RETREAT AT TIMBERRIDGE FILING NO. 4

UTILITY CONSTRUCTION DRAWINGS

FEBRUARY 2024

PCD No. SF-1827

RETREAT AT TIMBERRIDGE FILING NO. 4 CONSTRUCTION PLANS PUBLIC 8" PVC WATER PLAN			
DESIGNED BY	PRA	SCALE	DATE 2-29-24
DRAWN BY	PRA	(H) 1" = 50'	SHEET 2 OF 3
CHECKED BY	(V) 1" = N/A	JOB NO.	1185.31

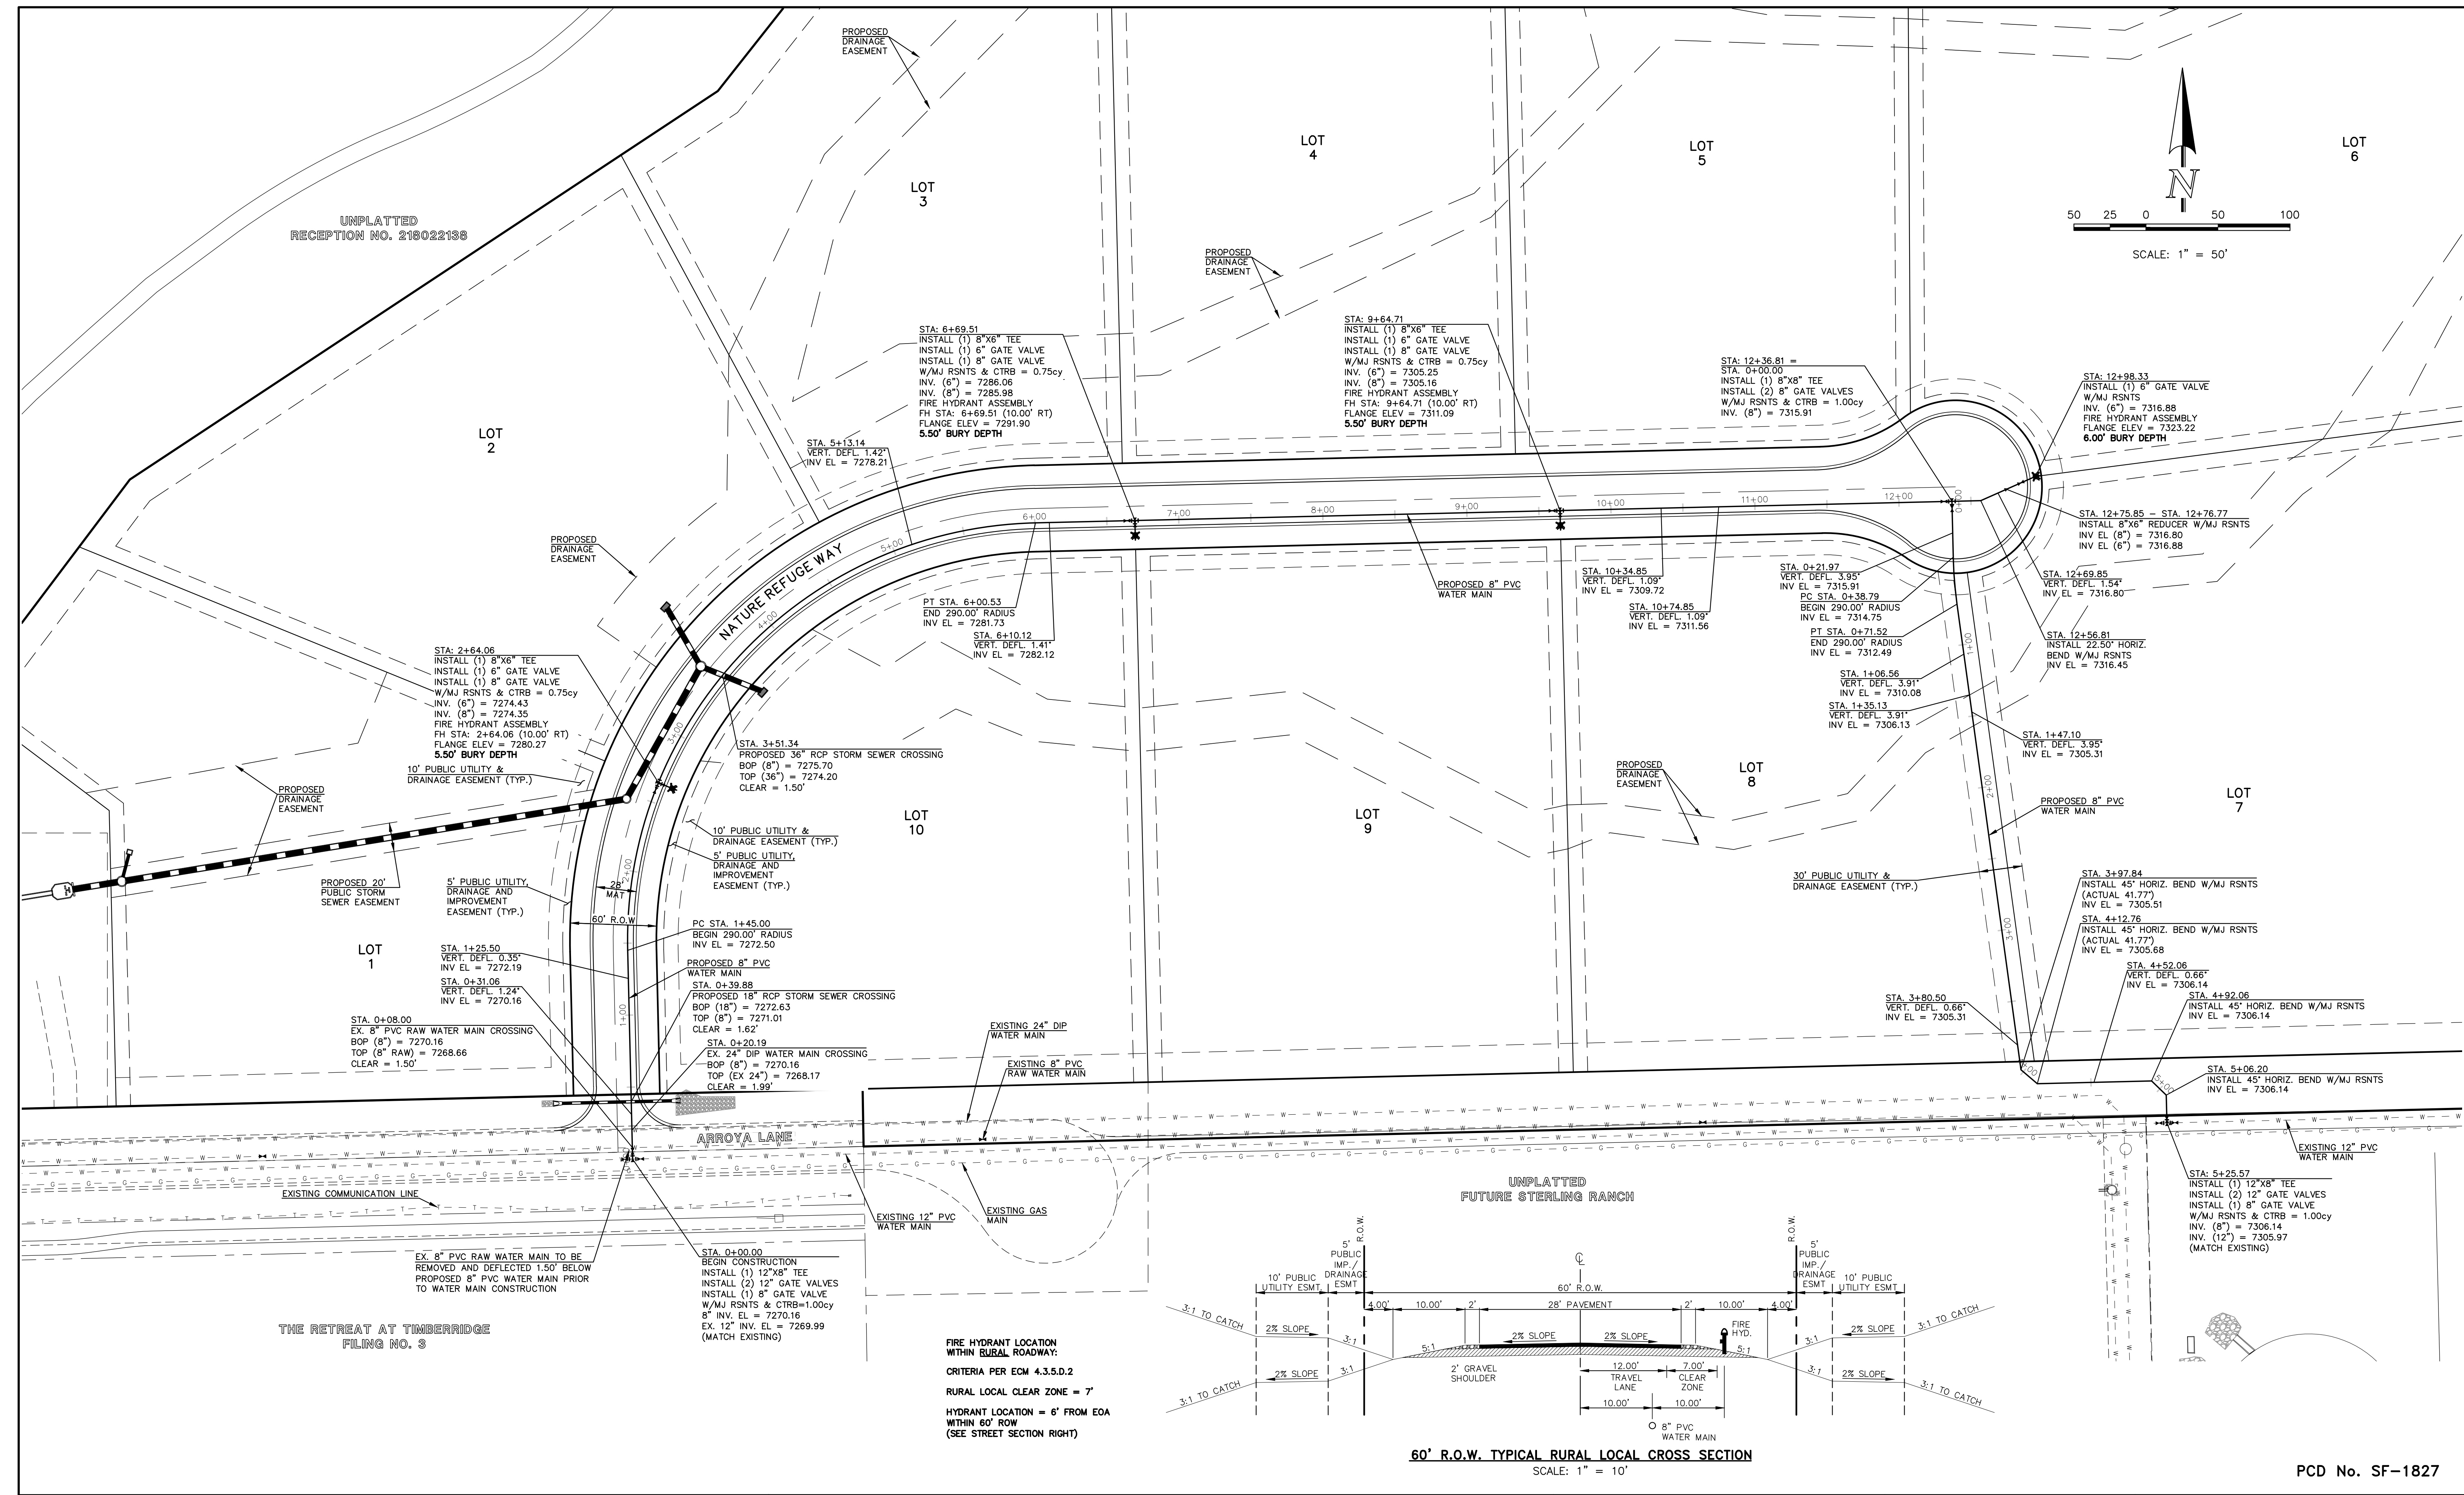
Provide a typical section on where hydrants will be placed in relation to clear zone and ditch
